Post Point CHN 215
Hertfordshire County Council
County Hall, Pegs Lane
HERTFORD SG13 8DN

Date 09 June 2017

RE: 6/2017/0585/FULL - University of Hertfordshire De Havilland Campus, Hatfield, AL10 9UF

Thank you for consulting us on the above application for the erection of a New Social Club, Landscaping and Associated Works, at University of Hertfordshire, de Havilland Campus, Hatfield, AL10 9UF.

SHEET TITLE
DRAINAGE LAYOUT

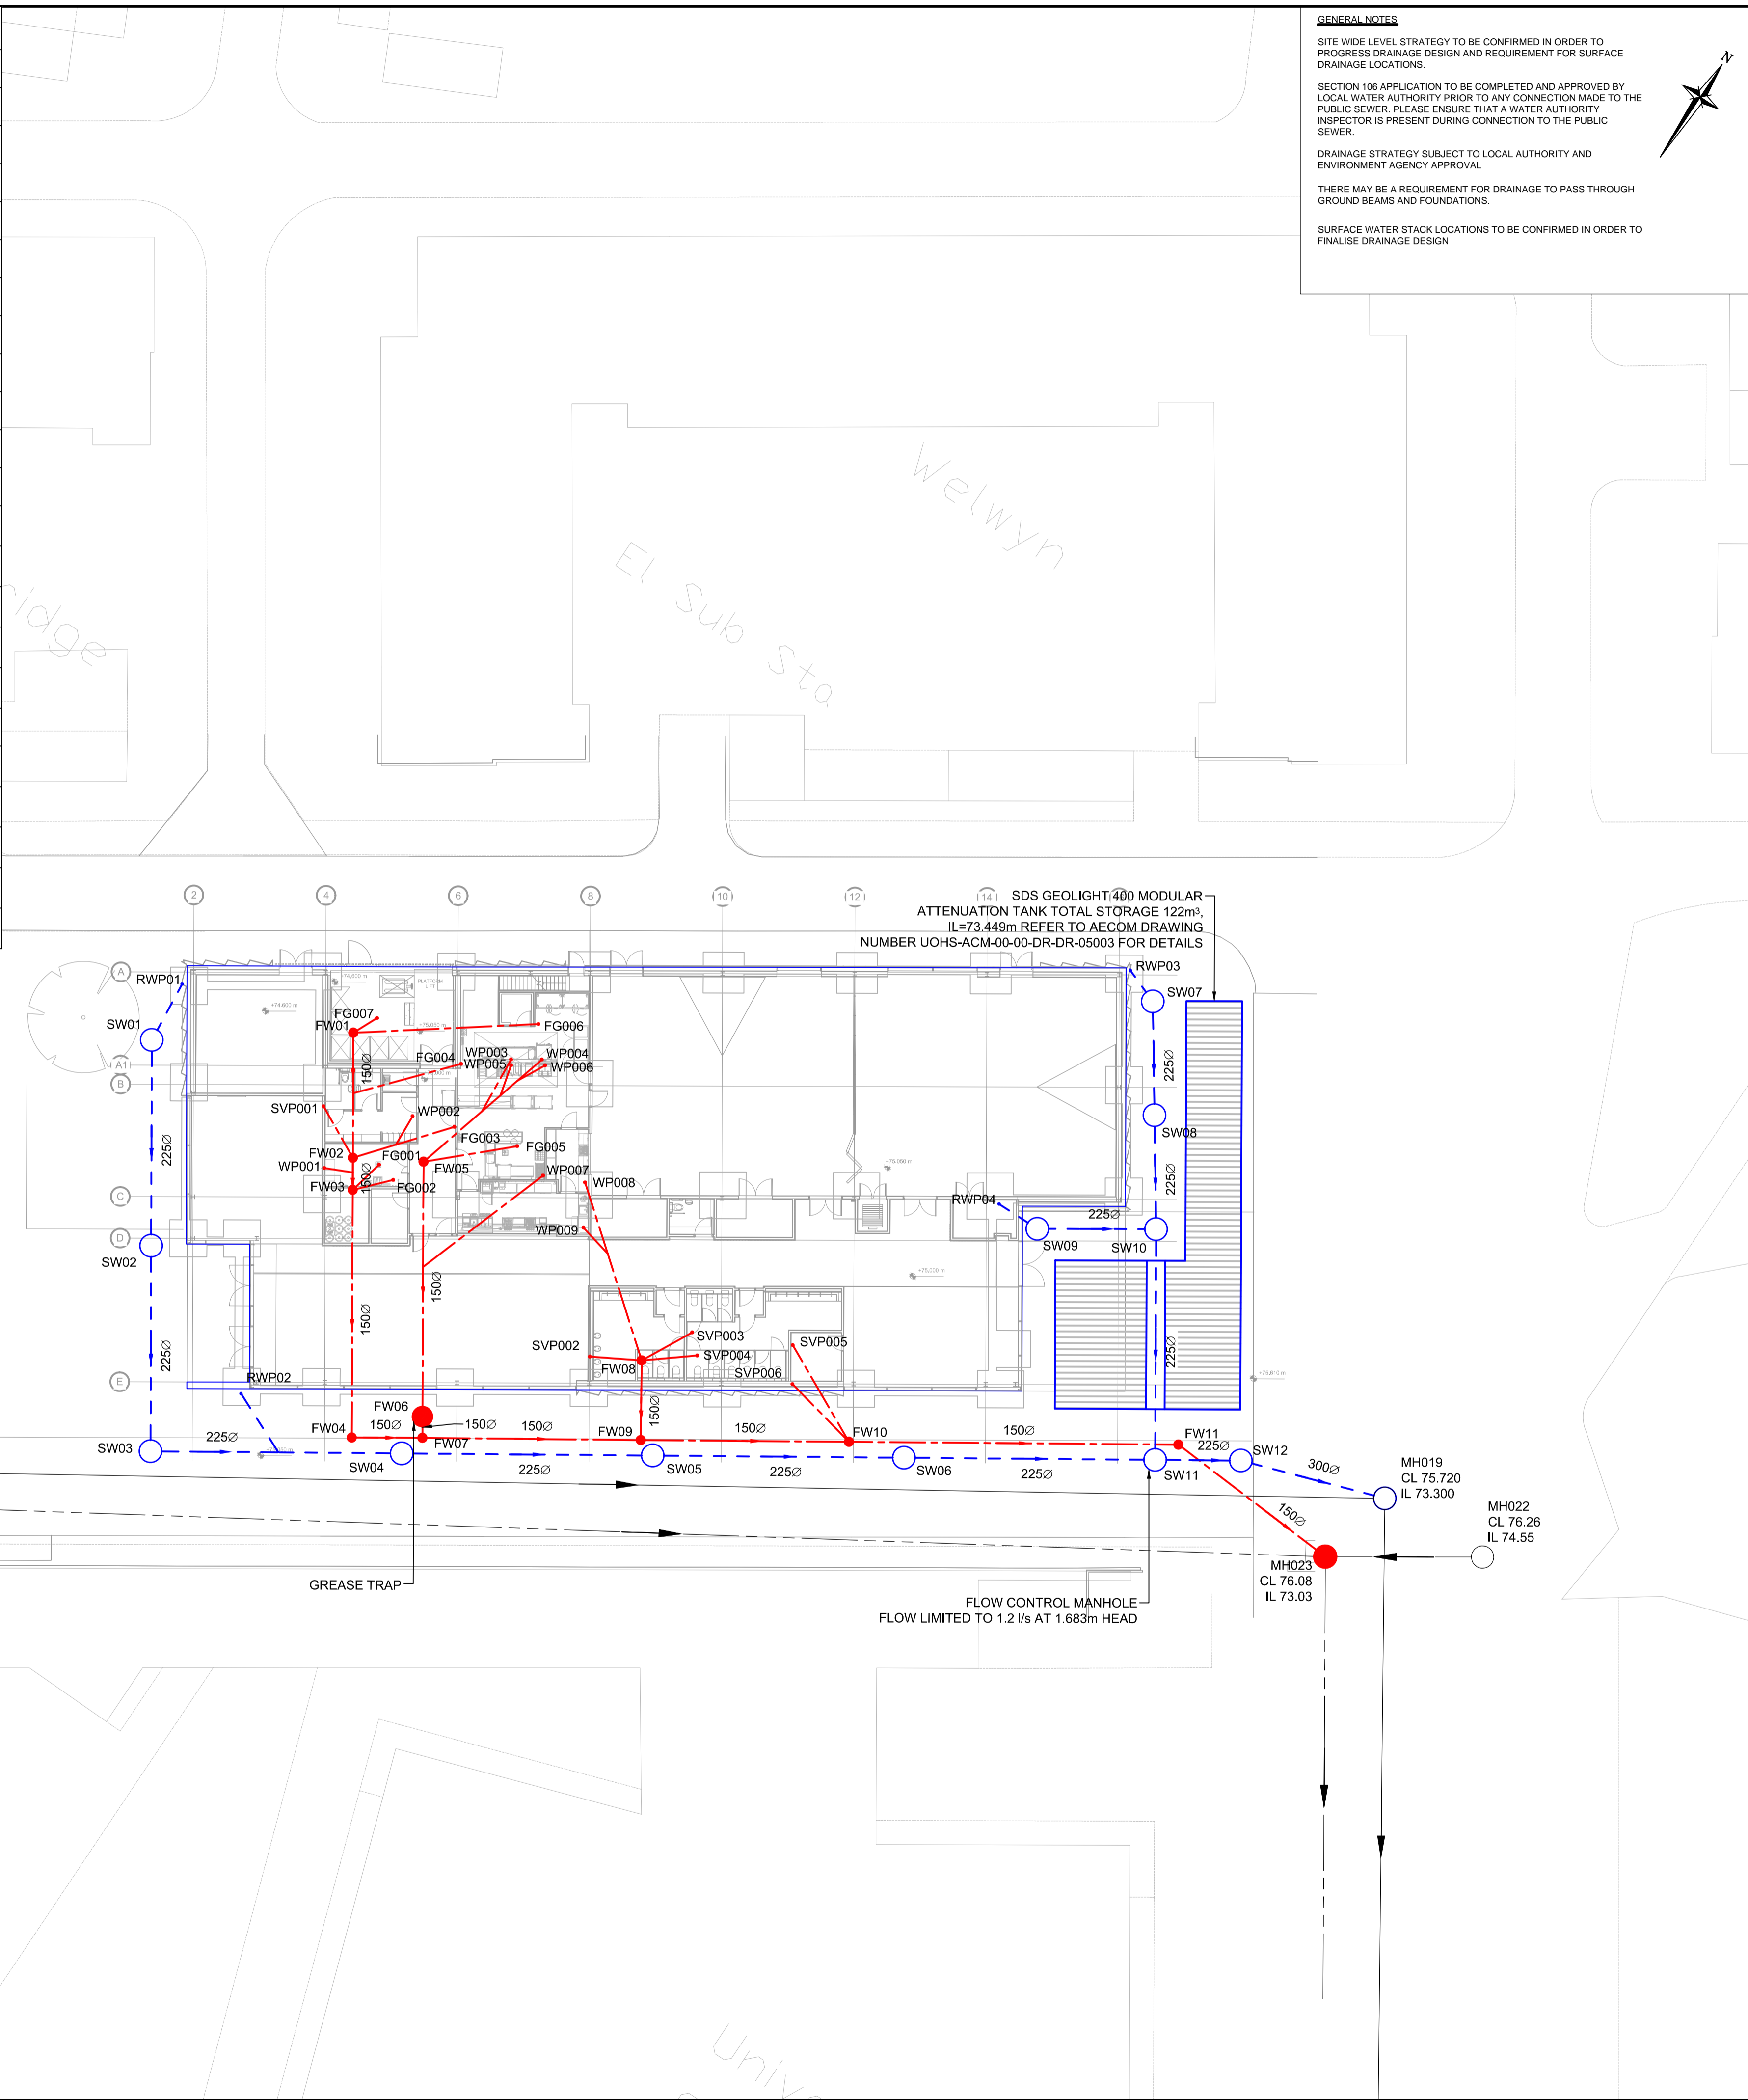
We note that the Applicant has proposed an appropriate drainage strategy. The proposal is to limit surface water discharge to greenfield run-off rate, equal 1.2 l/s. An underground tank with flow control is proposed within the scheme to provide attenuation volume. The current site is a greenfield area and the applicant should have explored a more sustainable approach including above ground solutions for surface water drainage strategy. Having said that, we would have no objection in principle to the grant of the permission.

No detailed drainage calculations have been submitted in support to the drainage strategy.

No development shall take place until a final detailed surface water drainage strategy has been submitted and approved in writing by the Local Planning Authority. This should include:

- Detailed engineered drawings of the proposed SuDS features including their size, volume, depth and any inlet and outlet features including any connecting pipe runs.

- Volume of surface water the site will have to deal with, supported by detailed drainage calculations for entire development site, and for all rainfall events up to and including the 1 in 100 year including a +40 % allowance for climate change.
